**WEST SUSSEX COUNTY COUNCIL
STRATEGIC PLANNING CONSULTATION**

SUBJECT: FP/36/12 - Detailed planning permission for temporary access for period of 18 months to serve first phase of residential development - amendment to previously approved FP/26/09 (Dual Parish with Yapton).

Site 6, Stanover Lane, Felpham, Bognor Regis, West Sussex, PO22

REV. No.	DATE	DESCRIPTION	INITIALS
Client			
David Wilson Homes			
BARRATT HOMES			
Project Felpham, Bognor Regis			
Title			
Temporary access into zone A			
Scale		Date	Drawing No.
As Shown		Jan 09	4180-530
Checked		Drawn	Rev
KIG		KIG

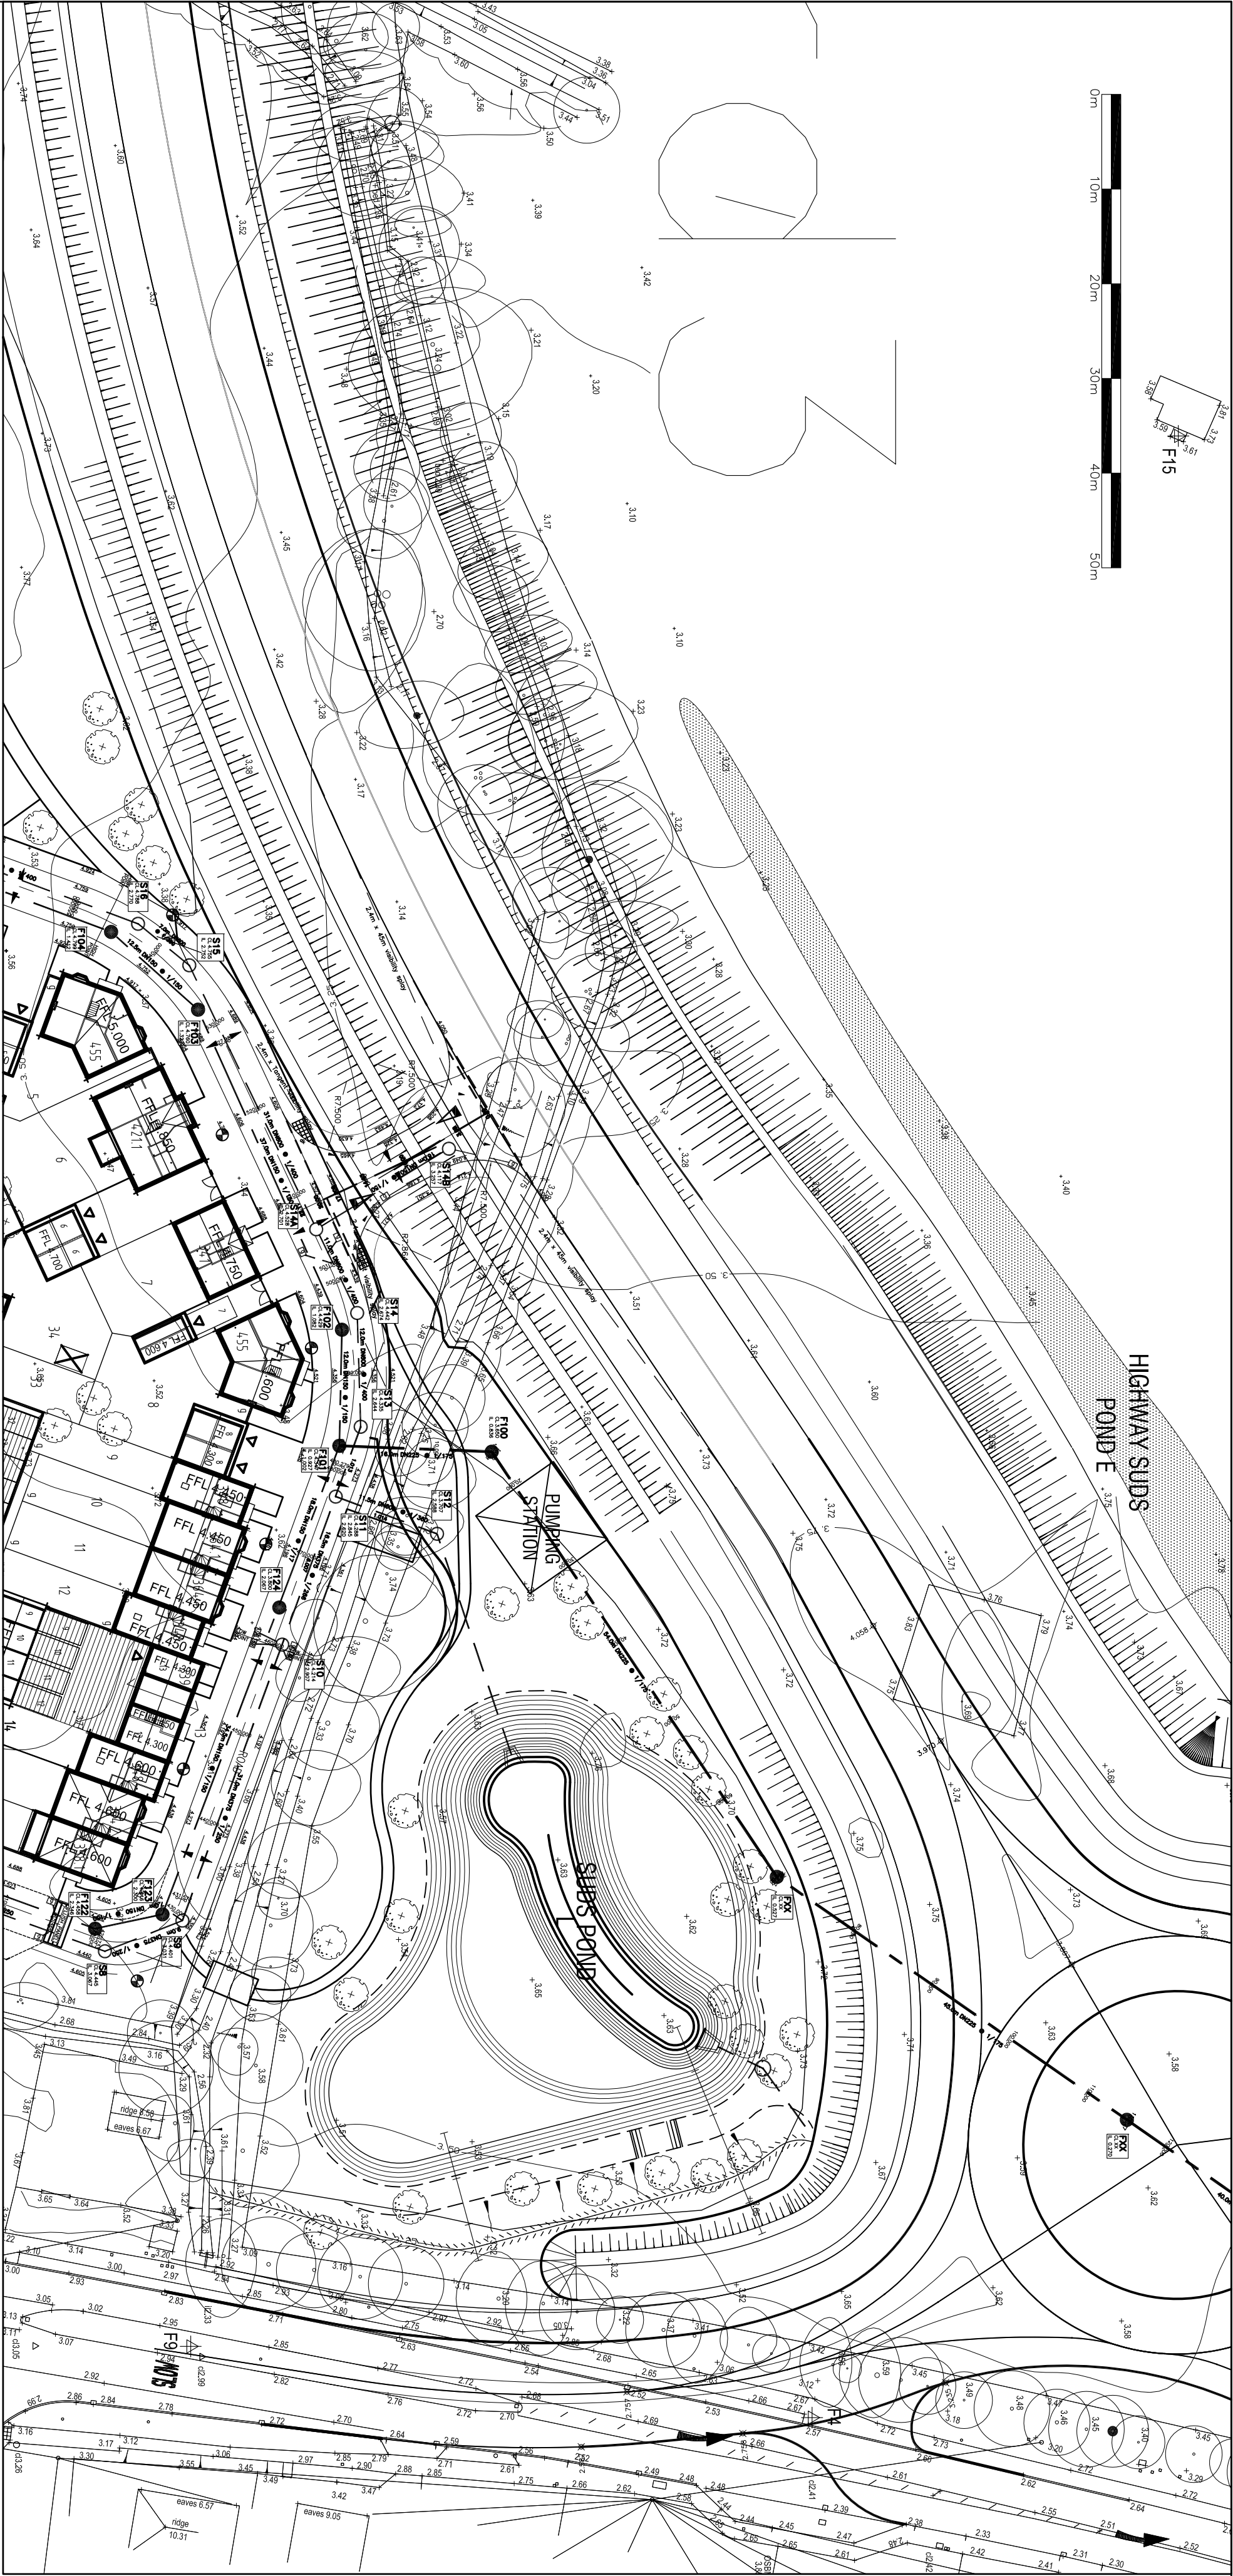
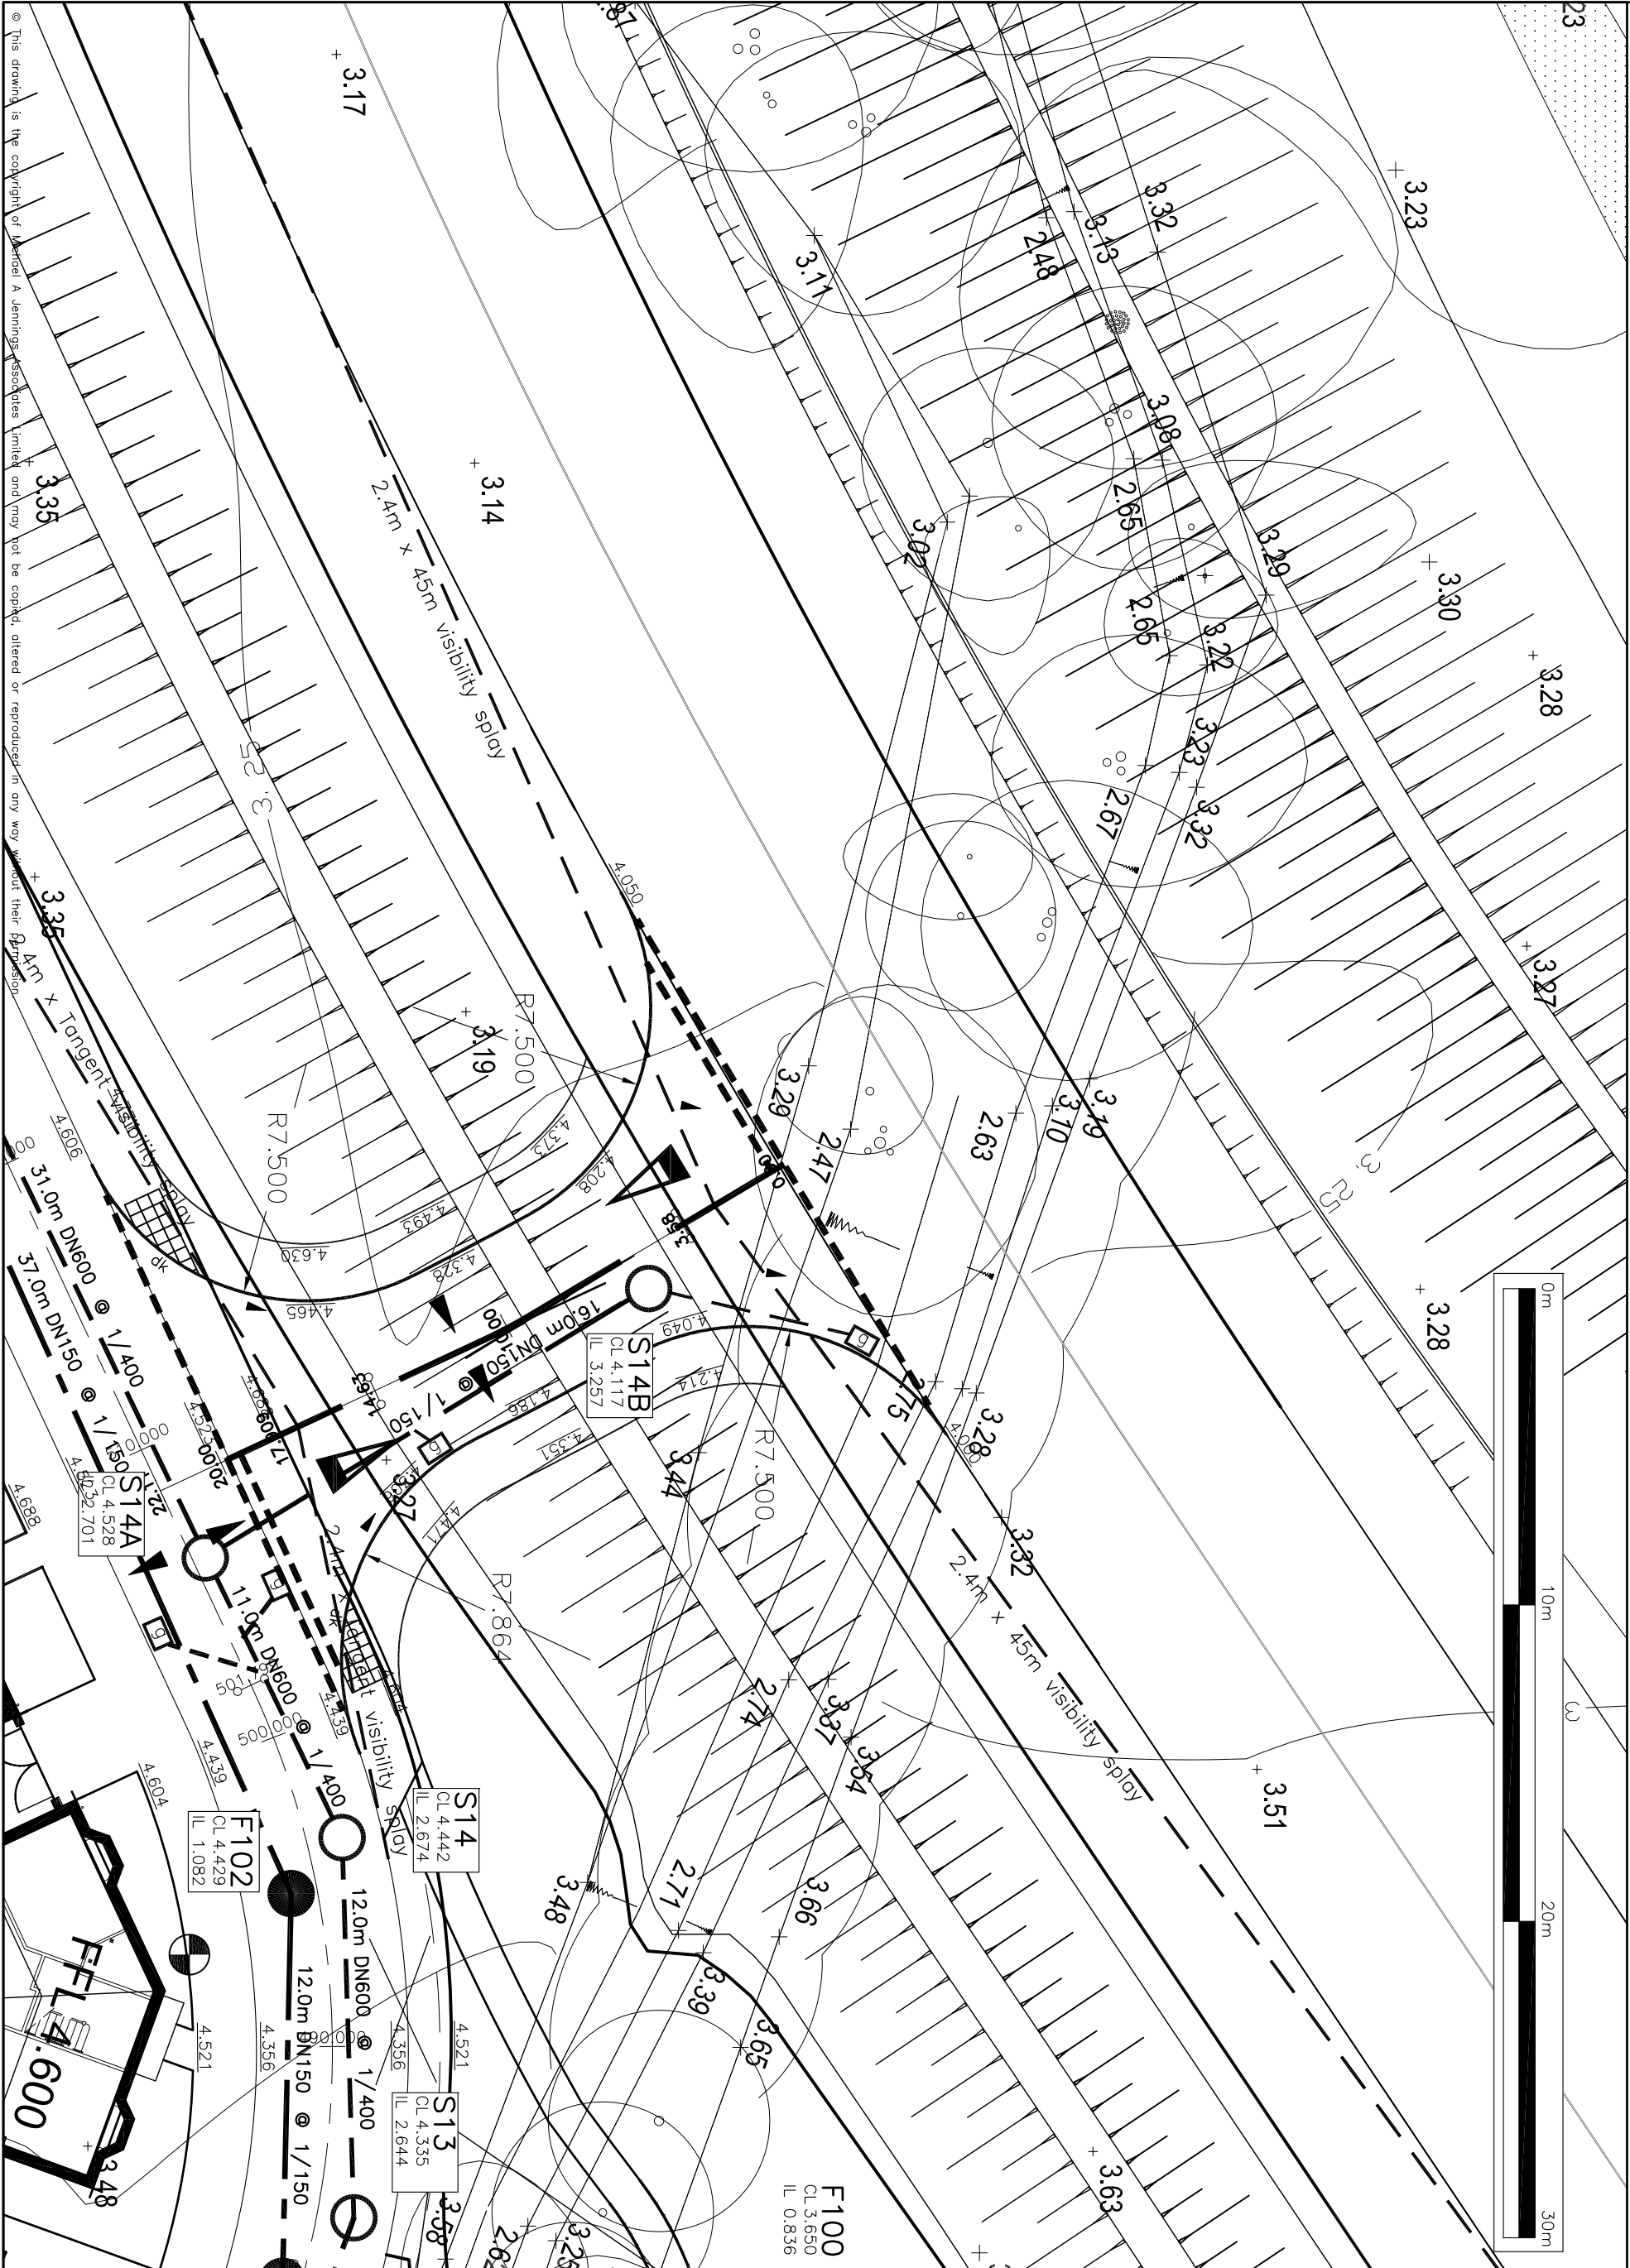
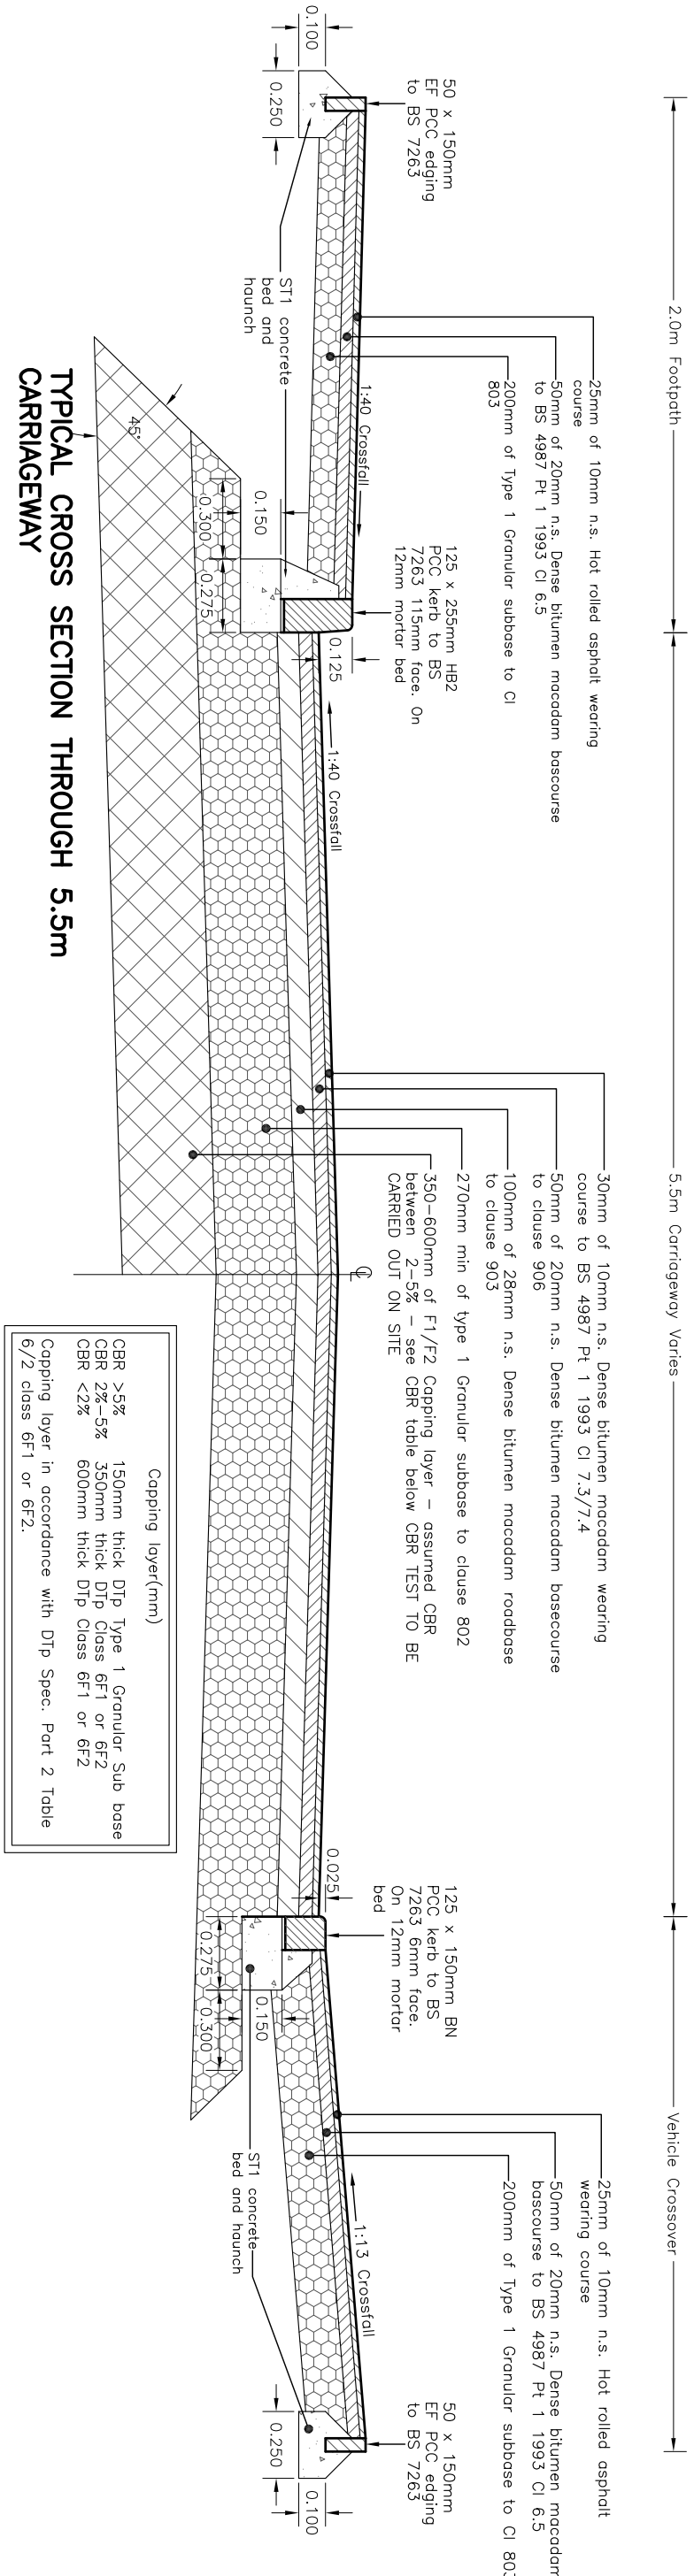
Visibility from the temporary access onto the BRRR is substandard, which was acceptable given its purpose and the low traffic flows. However, it is not acceptable onto a public highway with increased traffic flows and speeds. In addition, it is also possible that the BRRR (in its entirety) could open before the 18 month period is complete.

The highway Authority would therefore object to the 18 month period as proposed.

However it may be possible to accept a reduced time frame. The permanent access to the residential development is now complete and could be used to access the development. Can the applicant provide justification as to the need to keep the temporary access open for an additional period.
